GG119 ROAD SAFETY AUDIT RESPONSE REPORT

Project Title:	Smithy Place Lane, Honley, HD9 6PR
Project Team:	Sanderson Associates Consulting Engineers
RSA Report Stage	Stage 1 RSA
RSA Organisation:	Sanderson Associates Consulting Engineers
RSA Report Reference:	169955-001-02
RSA Report Issue Date:	17/09/26
Report Title:	<u>GG119 Road Safety Audit Response Report</u>
Reference:	169955-SAN-HGS-XX-RP-C-01-003

This Road Safety Audit Response Report relates to a Stage 1 Road Safety Audit carried out to the Public Right of Ways HOL/31/30, PROW HOL/31/60 & HOL/31/40, including improvements to the steps between Smithy Place and Smithy Place Lane, Huddersfield (Planning Application Reference 2021/92206).

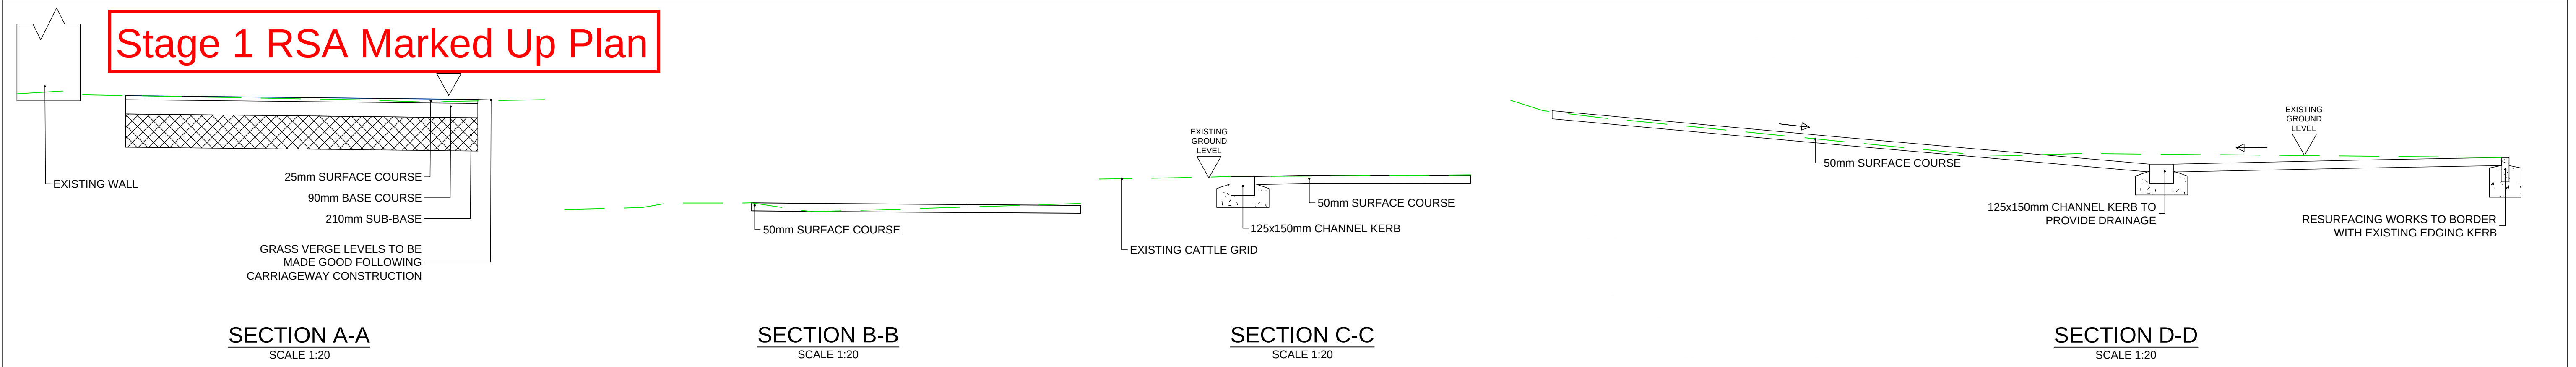
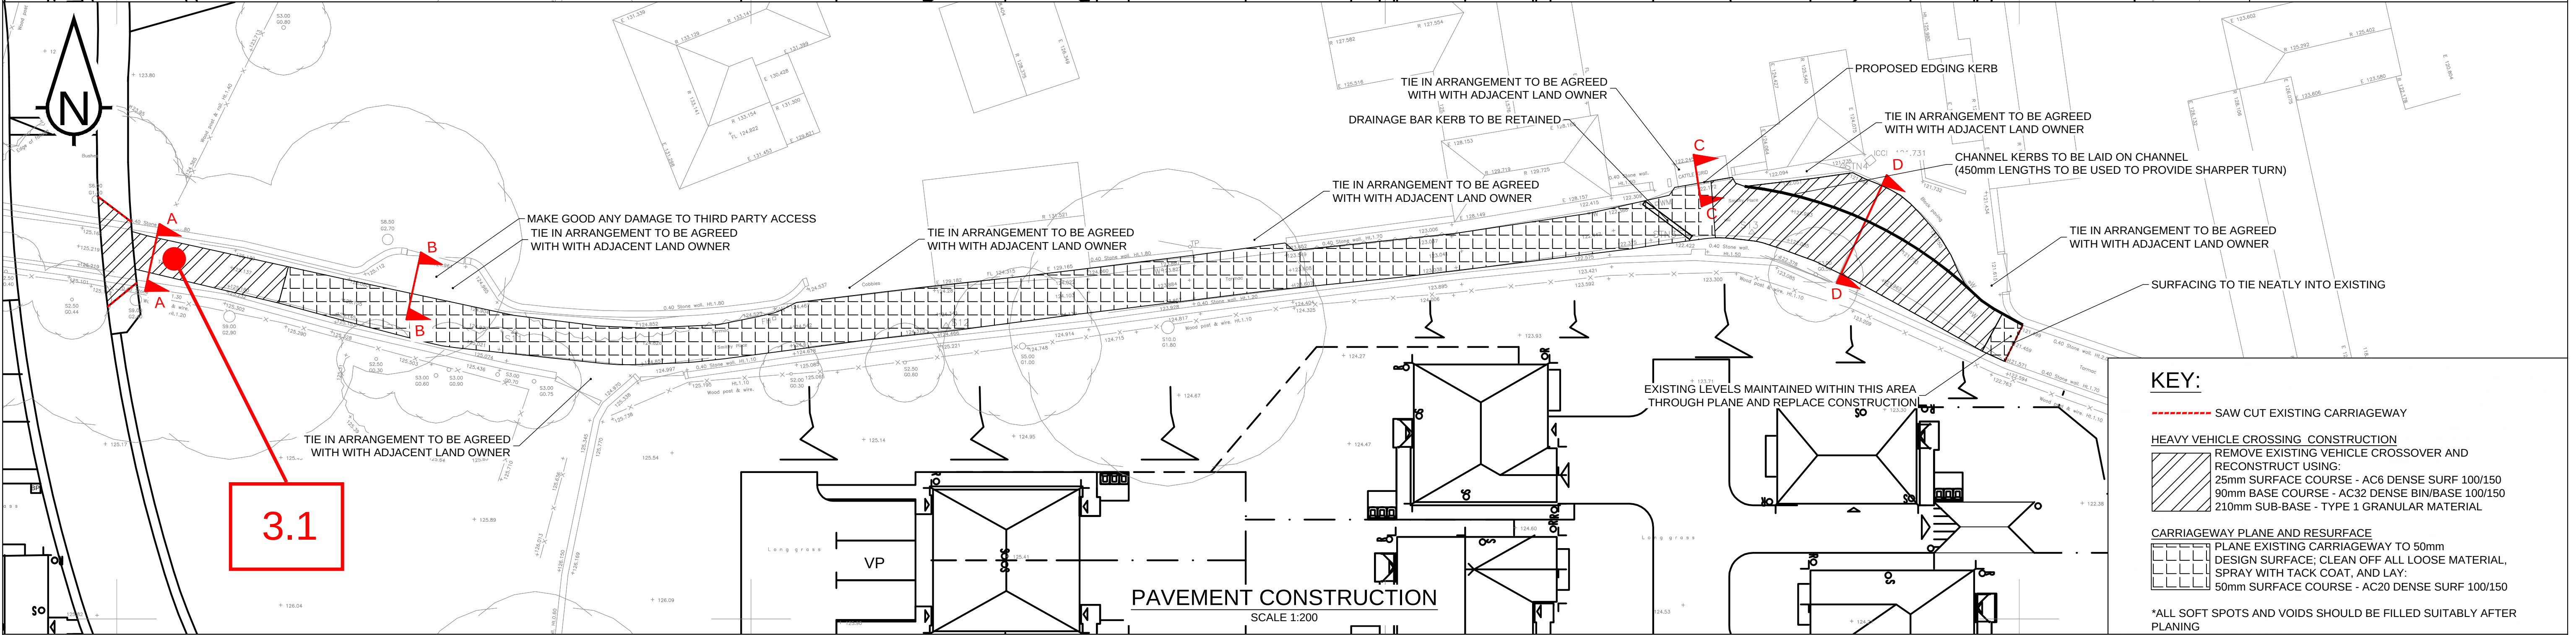
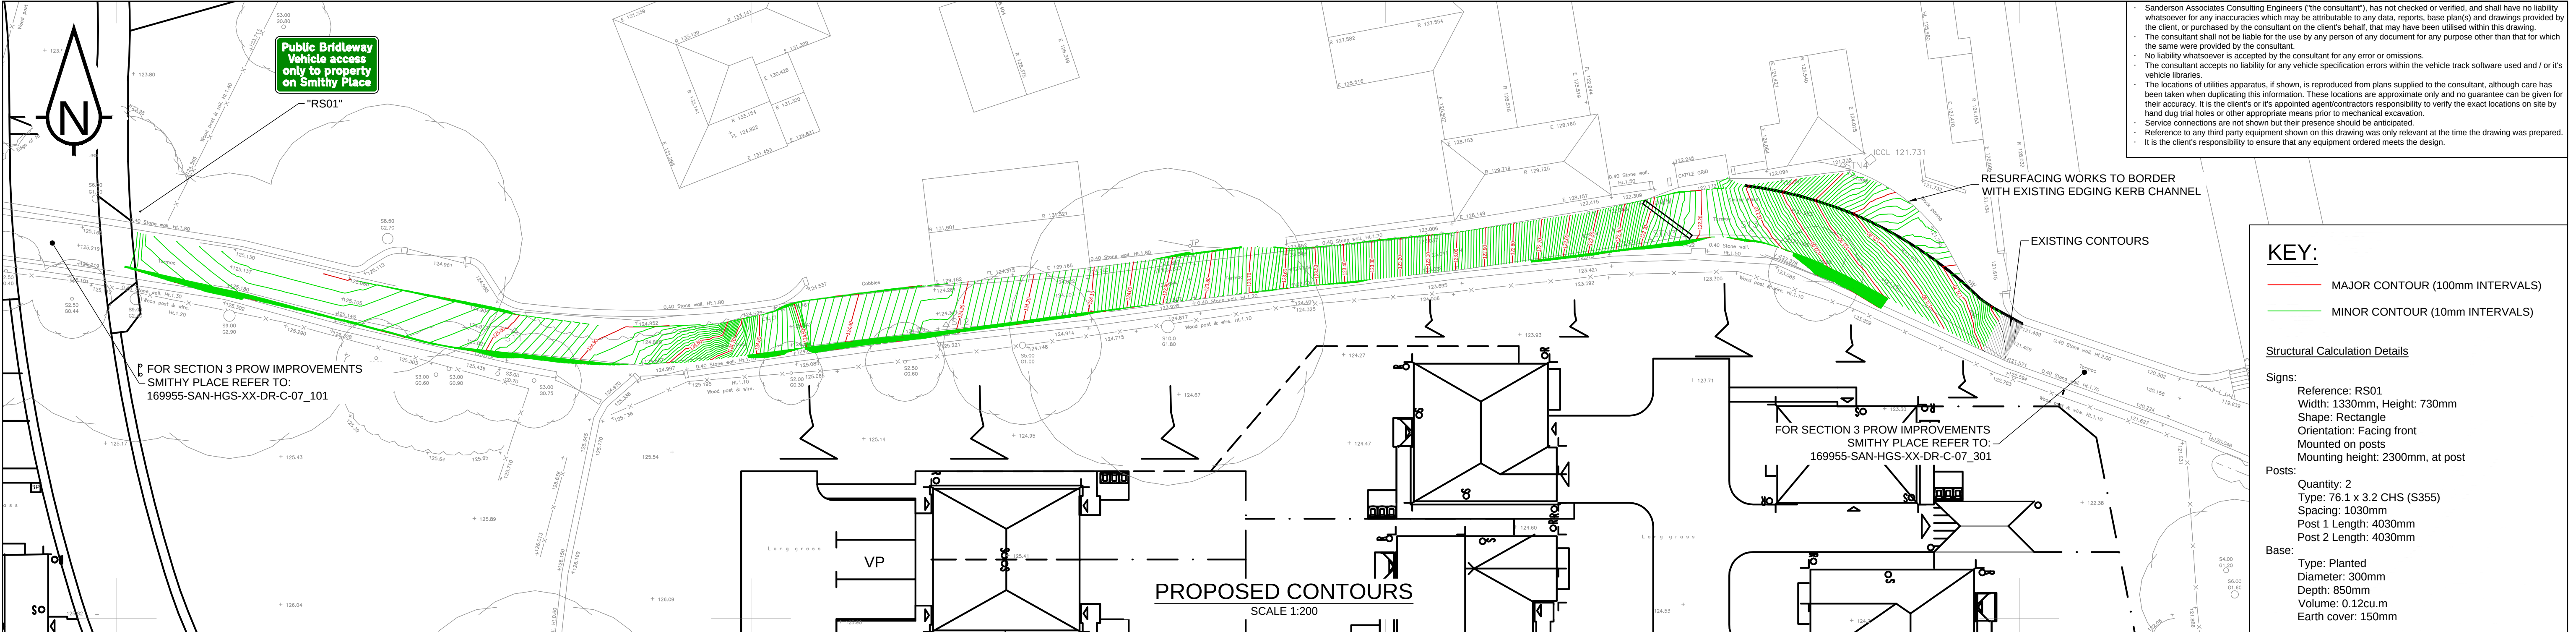
Summary: Potential Vehicular Access to The Residential Development

Detail: Vehicular access to the properties on Smithy Place is currently, and should remain, solely from the existing junction with Smithy Place Lane. However, the improvement works widen and improve the surface of the PROW, particularly along the short section beyond the last residential property, up to the crossing point on Oak Way, and the design includes a sign at the Oak Way crossing reading "public bridleway vehicle access only to property on Smithy Place". This wording, combined with the improved surface and width, does not preclude use of this section by existing residents seeking to egress into the Miller Homes development, nor does it prevent non-resident drivers from within the development using it to access Smithy Place or as a through route to Smithy Place Lane. Retaining any vehicular function on this short section introduces unnecessary conflict between vehicles and pedestrians, cyclists and equestrians, on a link that could otherwise be designed to promote NMU use exclusively. There doesn't appear to be an operational need for this section to accommodate vehicles in either direction, given that suitable vehicular access already exists via Smithy Place Lane.

Recommendation: It is recommended that the short section of PROW between the last residential property on Smithy Place and the Oak Way crossing is designed and signed to exclude vehicular access in both directions, including access/egress by existing Smithy Place residents, with a physical measure - such as a bollard, gate, or other restriction appropriate to NMU use - provided at this point, and that the proposed sign wording at the Oak Way crossing is amended to remove any reference to vehicle access, so that the existing junction with Smithy Place Lane remains the sole point of vehicular access to the properties on Smithy Place.

The Audit Teams Problem and Recommendation are noted, however due to the existing refuse collection strategy, which uses a small refuse vehicle/cage van utilising the existing PROW in a single direction due to limited turning facilities, either entering via Woodhead Road and exiting on to Smithy Place or vice versa, physical barriers or bollards would prevent vehicles accessing the existing properties.

It is therefore considered maintain the existing signage as shown on the current design drawings 169955-SAN-HGS-XX-DR-C-07_201 - Proposed Pavements (Sheet 1 of 3) and 202 Proposed Pavements (Sheet 2 of 3) are to be maintained.

The RSA Problem is noted, but the recommendation is not accepted. The Design Team Response is accepted.

Physical measures are not feasible to prevent all vehicles using Smithy Place, as the use of the route needs to be maintained to allow for refuse collection for the properties on Smithy Place. It is also likely that these properties (or at least some of them) benefit from historic access rights to use Smithy Place to access their properties, which also need to be maintained.

Therefore, the proposed advisory signage that states "public bridleway vehicle access only to property on Smithy Place" has been agreed with the PROW Team and Highway Authority and is considered to be

sufficient to highlight to the public that the route is a bridleway and should not be used by unauthorised vehicular traffic. This approach is consistent with other similar locations in Kirklees, such as Hassocks Lane, Honley, which is signed in a similar manner.
<u>Post-RSA Action</u> <u>No further action required.</u>
*****End of RSA Stage 1 Decision Log *****
